**REQUEST**

Current Zoning: N1-A ANDO (Neighborhood 1, Airport Noise Disclosure Overlay)  
Proposed Zoning: I-1(CD) ANDO (Light Industrial, Conditional, Airport Noise Disclosure Overlay)

Approximately 10.34 acres located north of Shopton Road, east of Sandy Porter Road, and west of Pinecrest Drive.

Staff recommends approval of this petition upon resolution of outstanding issues related to transportation and land use.

TECHNICAL DATA SHEET

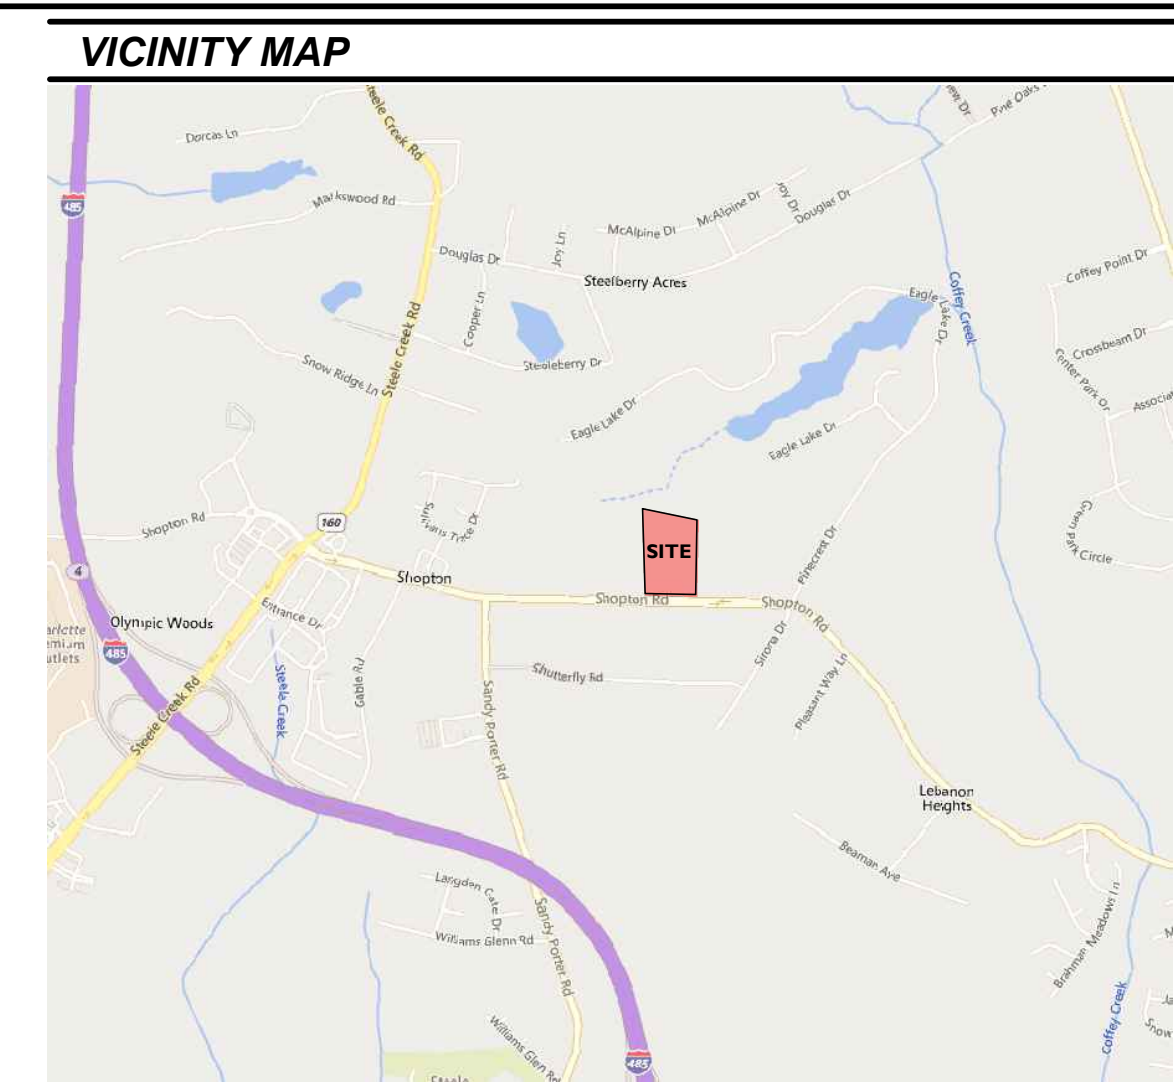
1. Label and dimension the right-of-way from the road centerline.
2. Revise site plan and conditional note(s) to commit to construct an 8-foot planting strip, and 8-foot sidewalk on Shopton Road per Chapter 19. The site plan shall label and dimension both items from the back of curb and gutter or edge of pavement.
3. Revise site plan and conditional note(s) to commit to construct bicycle facilities by locating the curb and gutter 27' from the center line to meet the Council-adopted Charlotte BIKES Policy. Revise the bike lane to 5' wide with a 3' buffer.
4. Per coordination with NCDOT, revise site plan and conditional note(s) to commit to installing a left turn lane into the site from Shopton Road.
5. Per coordination with NCDOT, revise the site plan to remove the sites eastern access. Line access up with the driveway across the street.

6. Add the following uses to the list of prohibited uses in the conditional notes: automobile service stations, automotive repair garages, junk yards, petroleum storage facilities, landfills, and quarries.
-
